Project Name: Lot 2, Blackwood Crossing Filing 1A (AR DP 17-00765-A1MJ21)  
Review Number: 2

Thank you for your recent comments on 02/18/2022 regarding the Development Plan submittal for Lot 2, Blackwood Crossing Filing 1A. We have prepared the following responses which address those comments and have included the necessary resubmittals in PDF format. Please feel free to call us with any questions or concerns.

PHOTOMETRIC PLAN

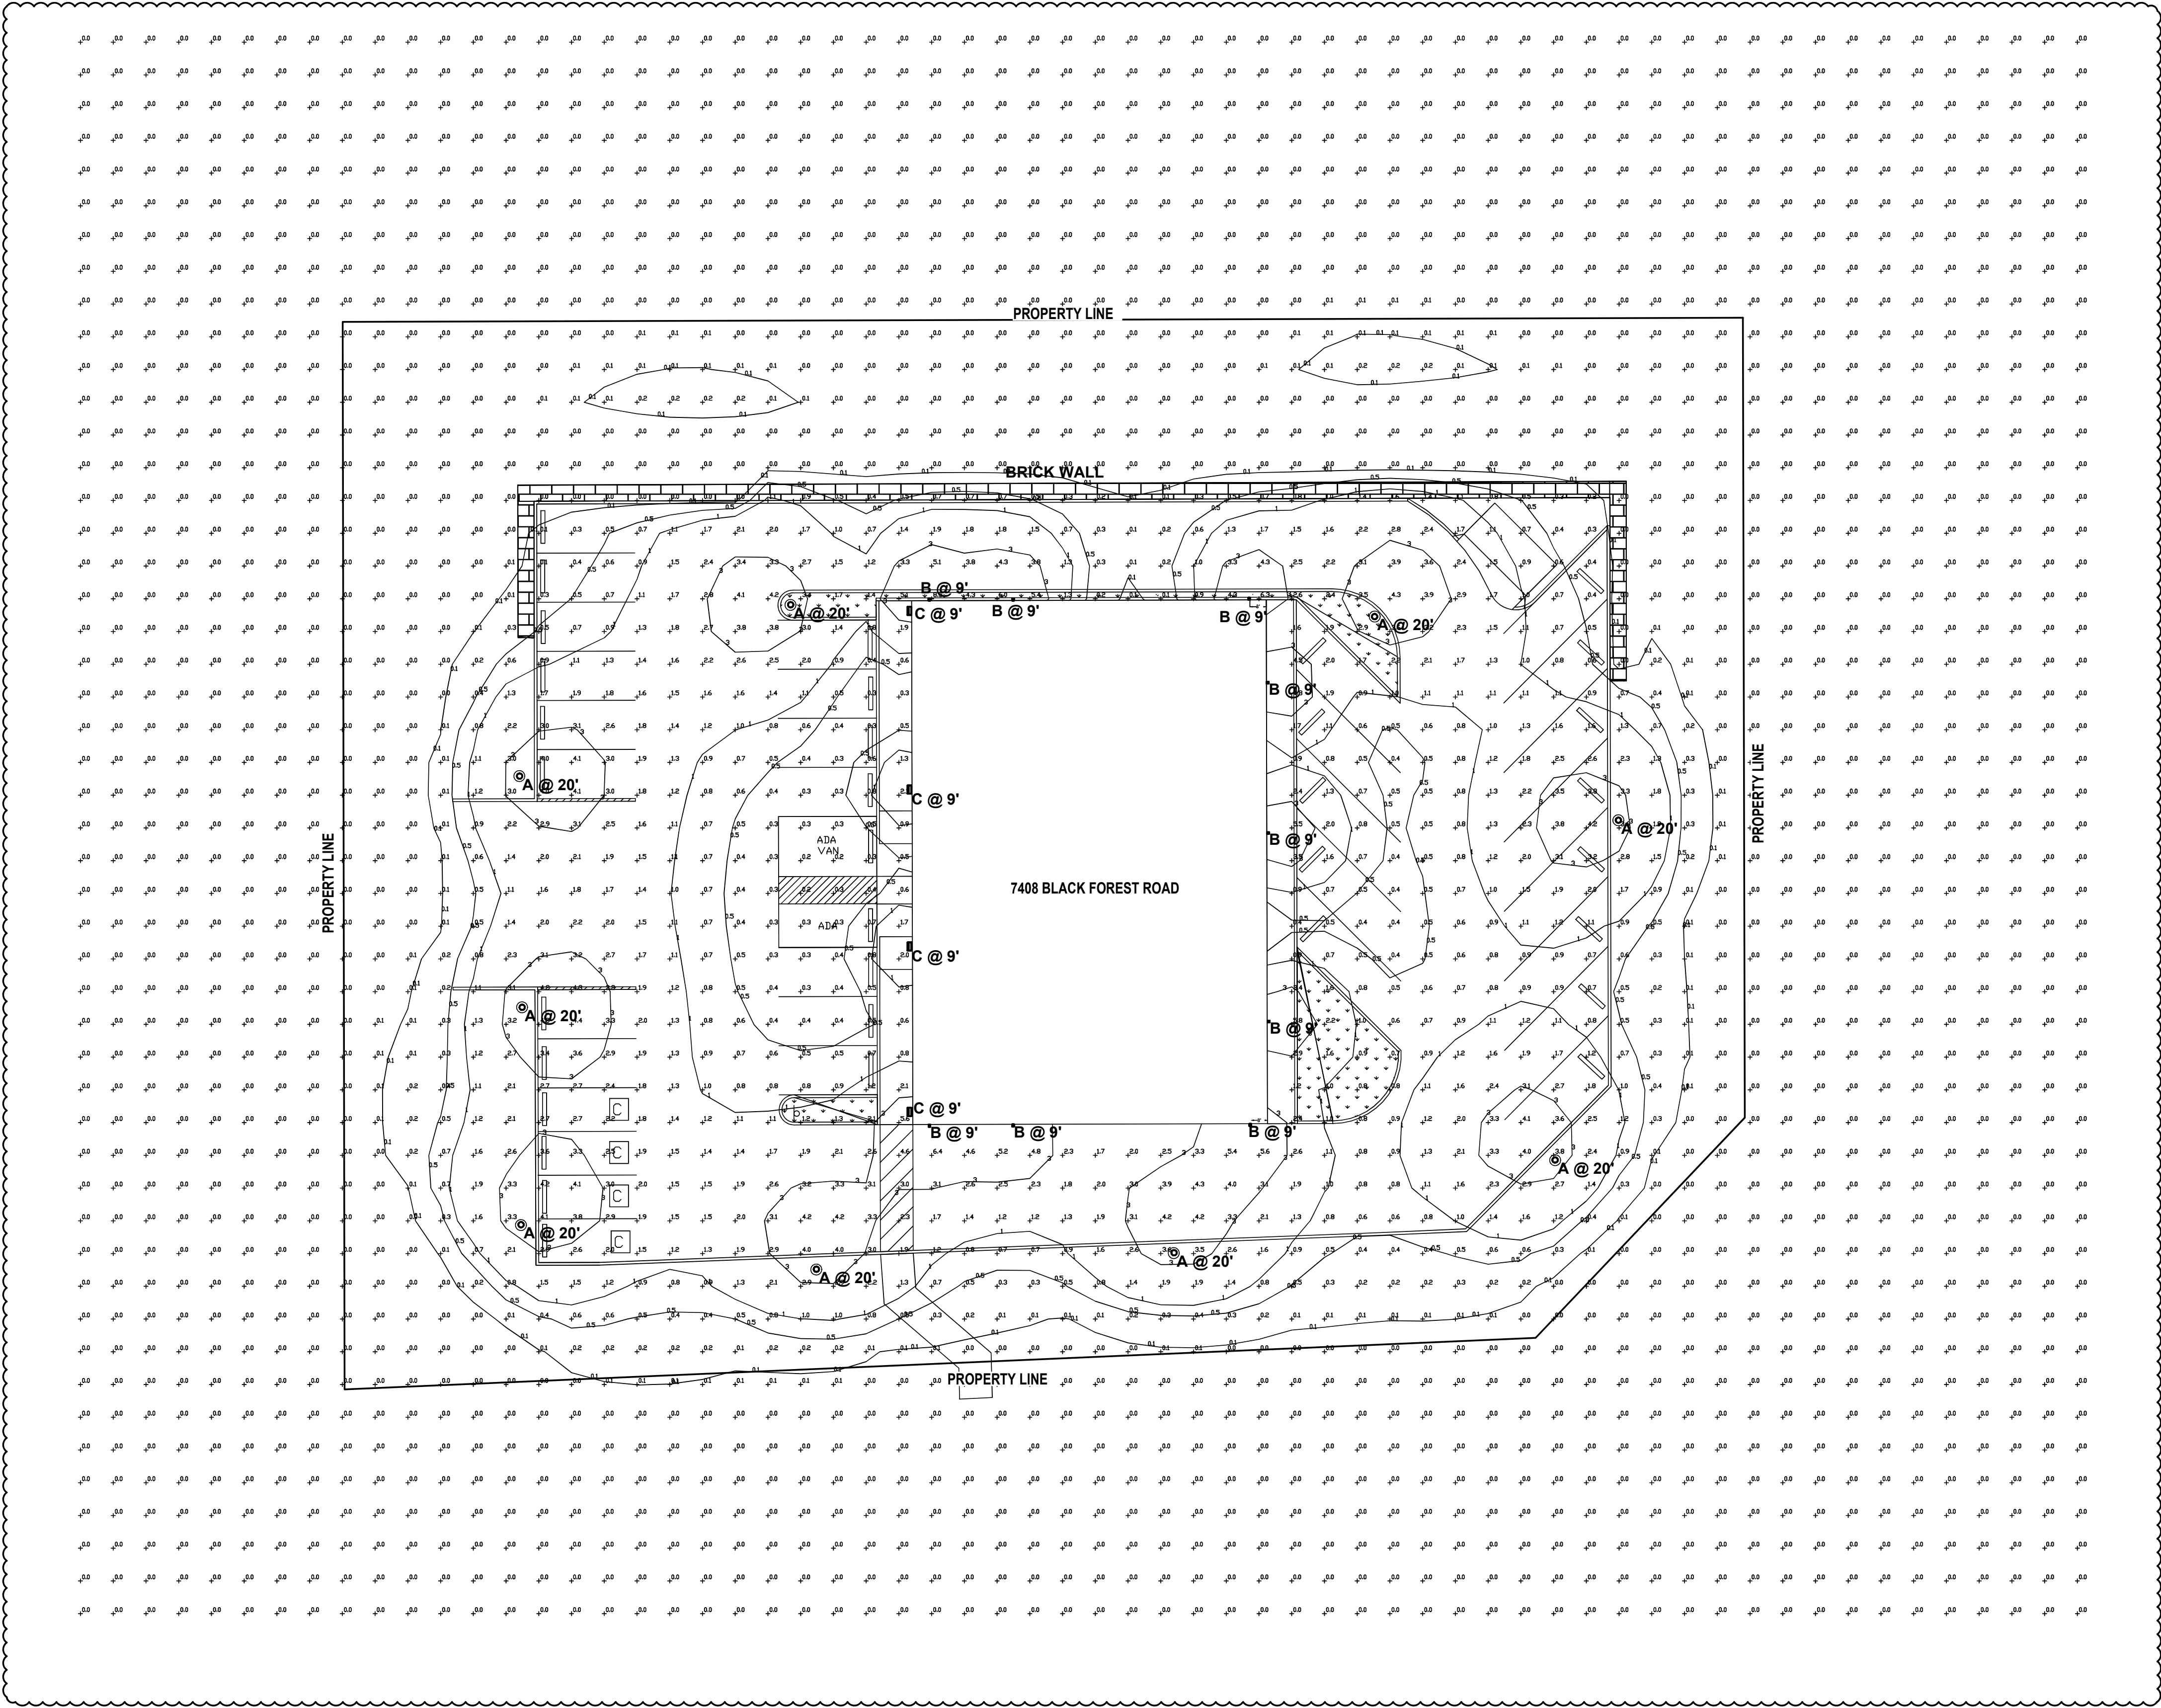
h. Show and label all proposed parking lights on the plans, revise as needed. (FLP check list 15)

**Response: These were previously shown but have been shaded and labeled to help clarify.**

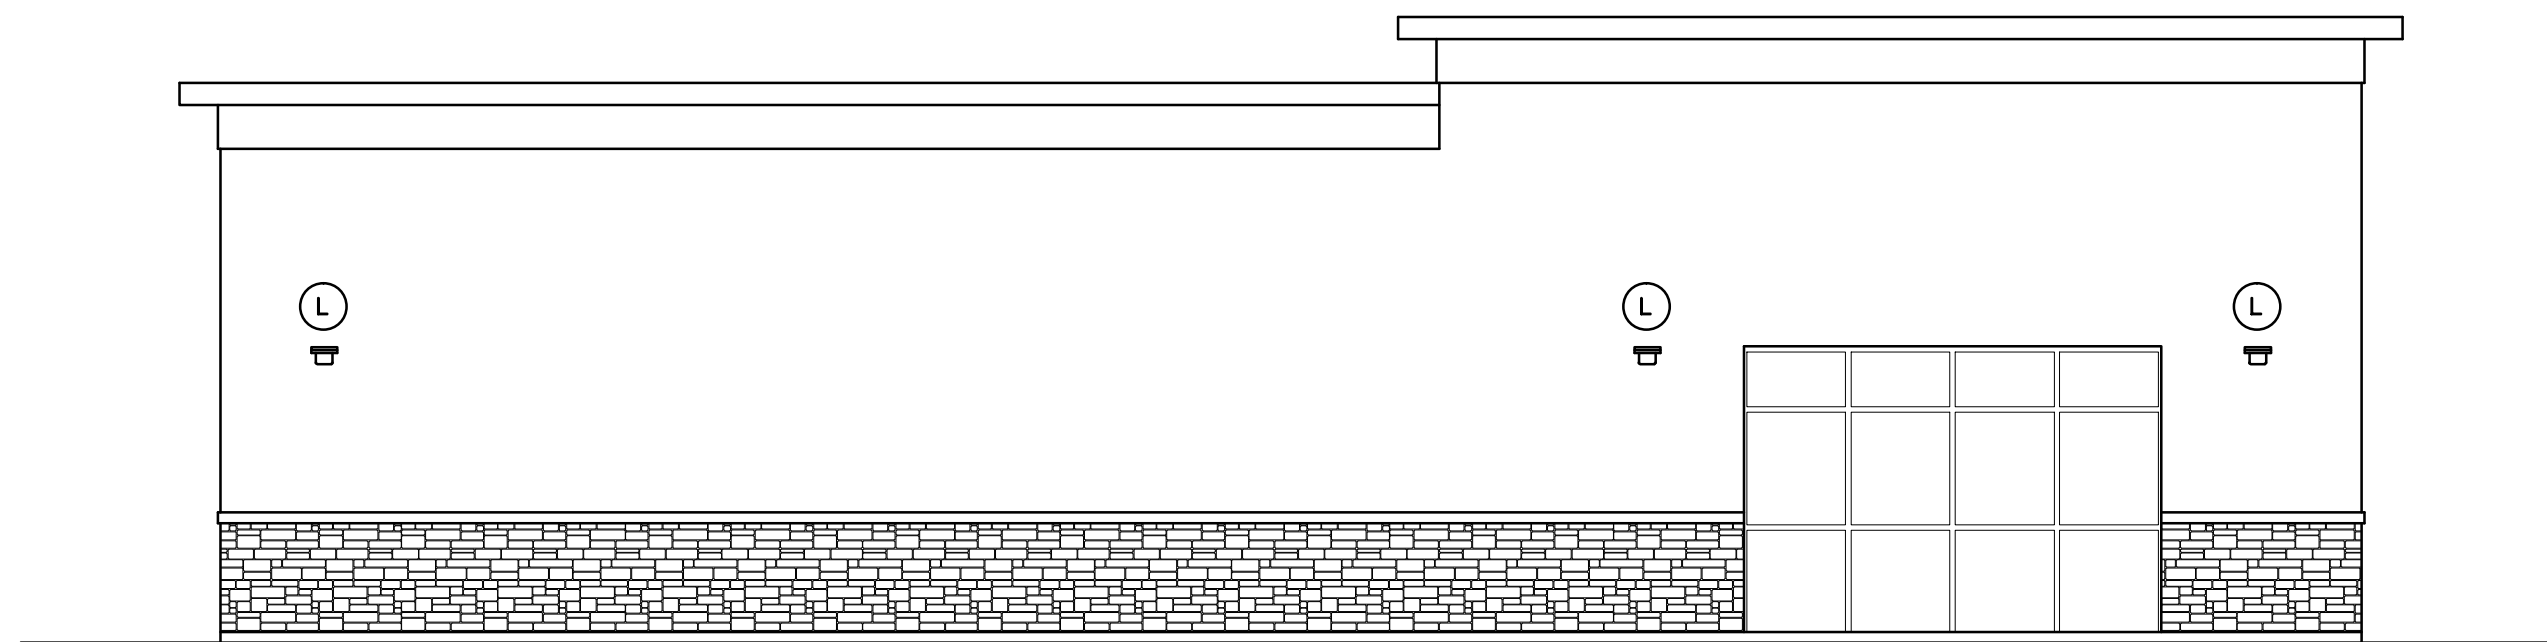
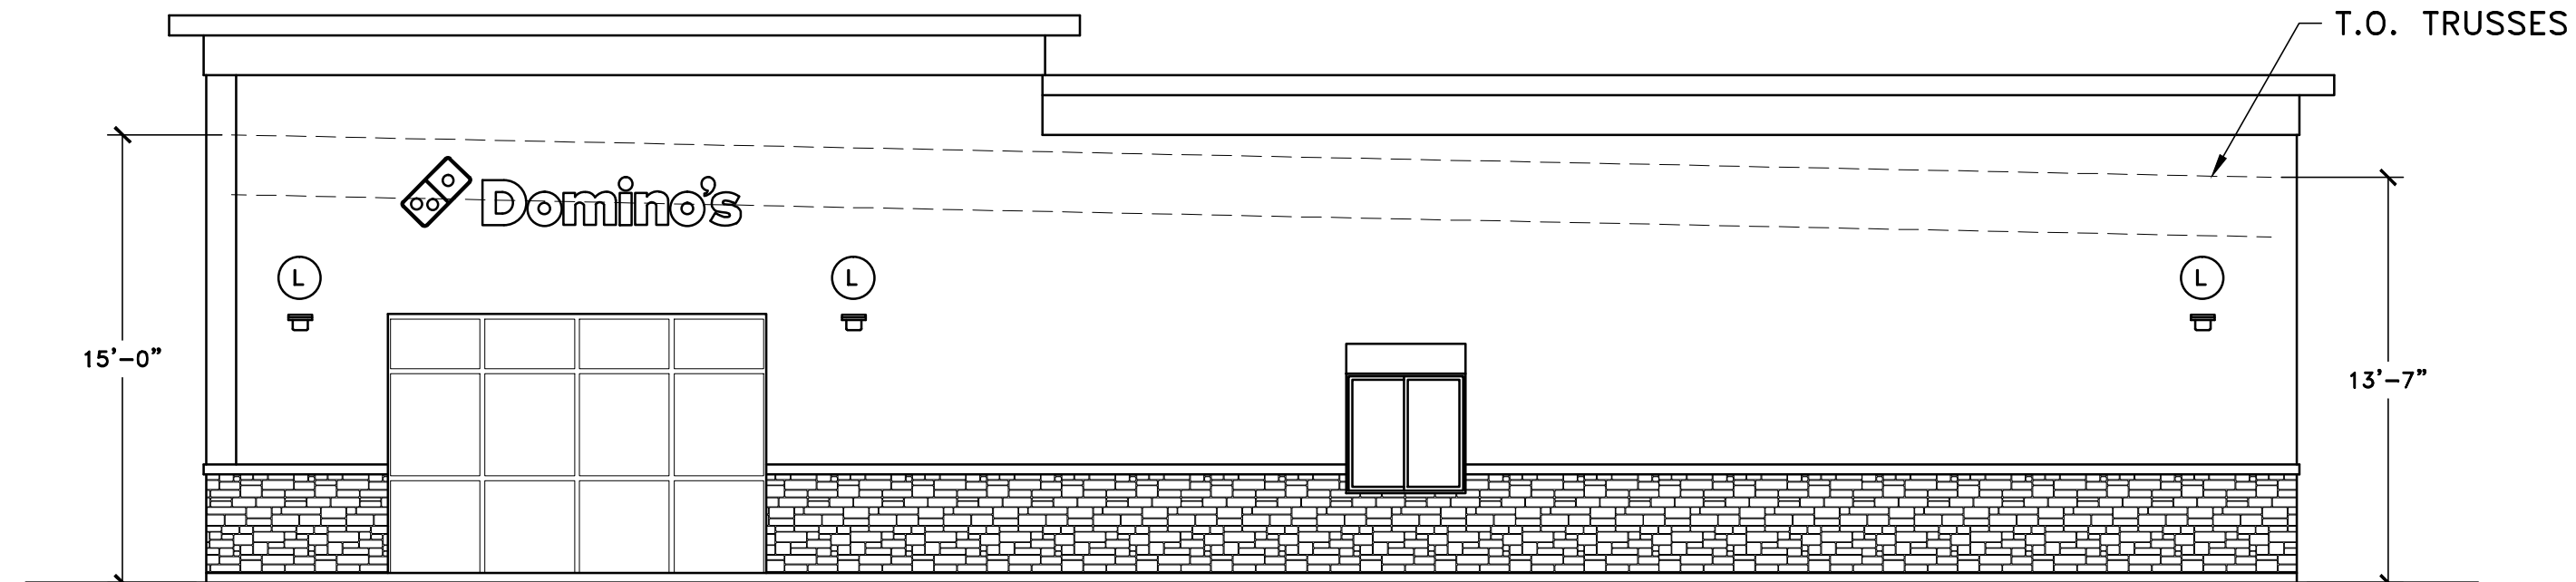
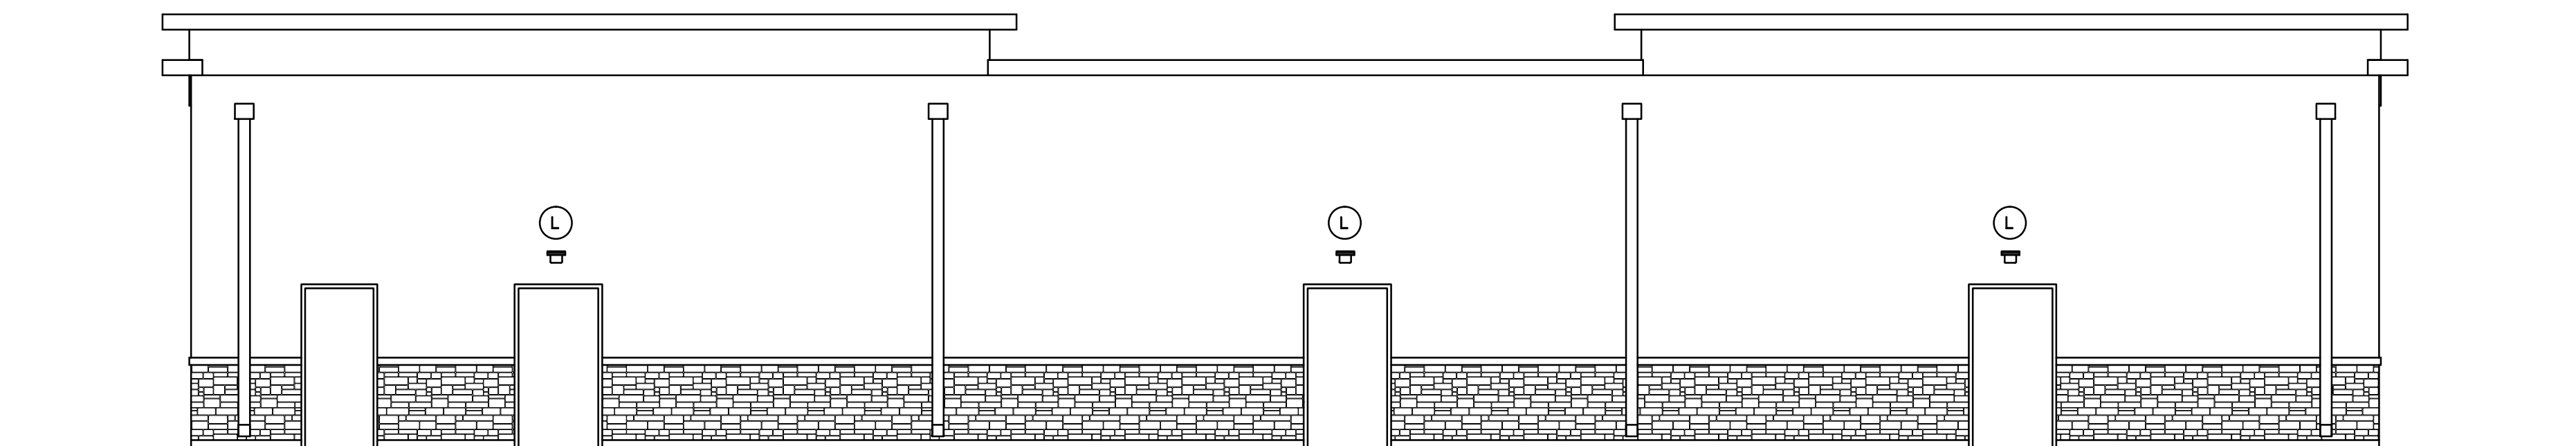
3. Building elevations are required. Please label the elevations with heights measured in accordance with City Code to show building height.

- A. The east façade has no ornamentation or variation in materials, please consider 360 degree architecture.

**Response: Updated features have been added to the exterior.**
